16 October, 2018

Planning Application Ref. FP/195/18/PL.
Re. 2 Second Avenue, Felpham.- Proposed two storey dwelling.

## PROPOSED STREET ELEVATION

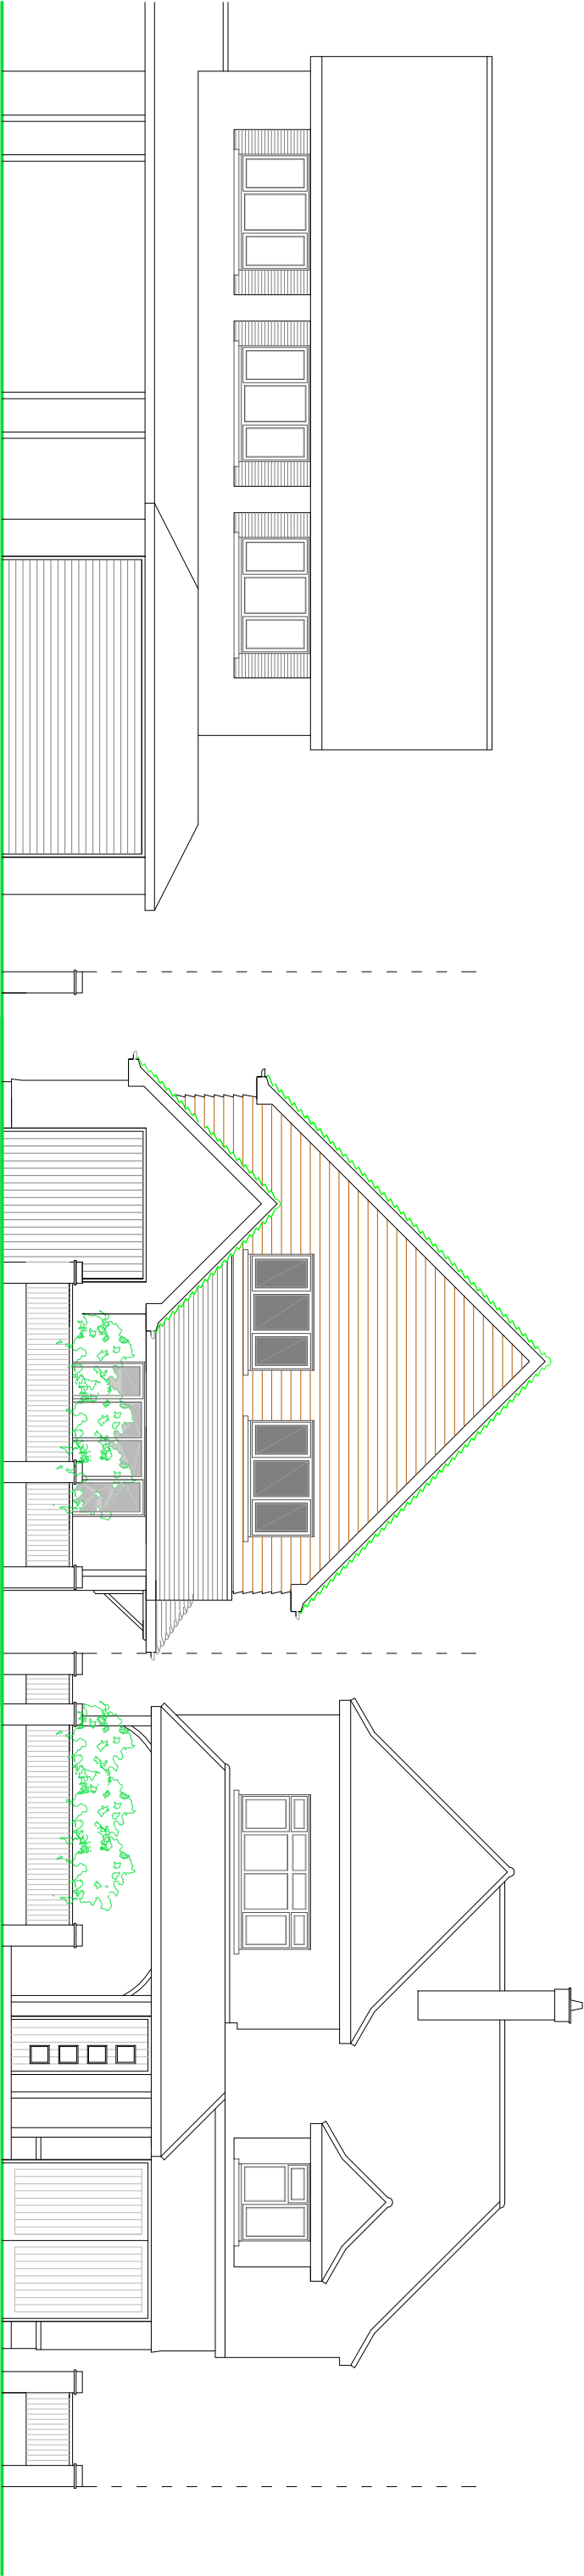
- 1.. The plan showing the position of the next door south property Shergar is STILL incorrect (side extension not shown) and gives a misleading impression of how the new property will affect the character of the road. Who is responsible for checking applications? Does this mean the plans will be affected by some of your regulations?
